13 June 2023

**State Significant Development Application SSD-45242780
Orana Battery Energy Storage System**

**ORANA BESS
ENVIRONMENTAL NOISE ASSESSMENT REVIEW**

Figure 1 – Development footprint, Surrounds and Receiver Locations

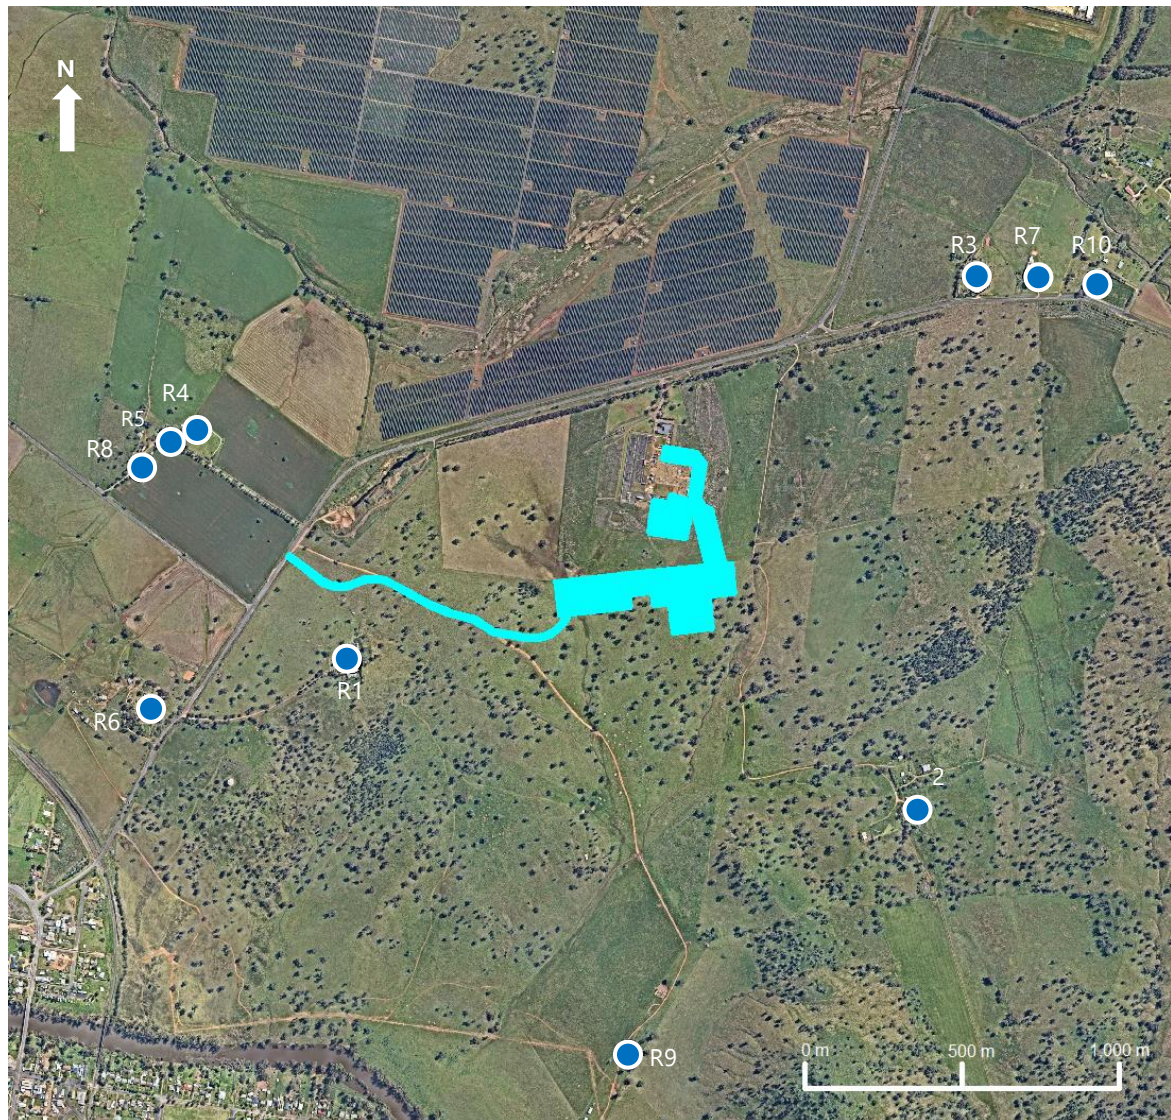
- 9 Figure 1-4 of the EIS identifies 'nearby receivers' to the Orana BESS development. The Homestead on the Property is identified on this map as Receiver 'R2' (a non-associated residential receiver) and is referred to throughout the EIS. However, the Farm Cottage located on the Property, which is situated 150m closer to the Orana BESS development area than Receiver R2, has not been identified as a residential receiver in Figure 1-4 or anywhere else in the EIS.

- 24 Further, the Noise Report fails to:
- (a) identify the Farm Cottage located at the Property as a residential receiver;
 - (b) assess the noise impacts of the Orana BESS on the Farm Cottage, which is located 150m closer to the development area than receiver R2; or

- Receiver R2 shows a single residence, but it is understood that there is a second residence, closer to the proposed BESS.
- The cumulative noise assessment does not include the Wellington South BESS.
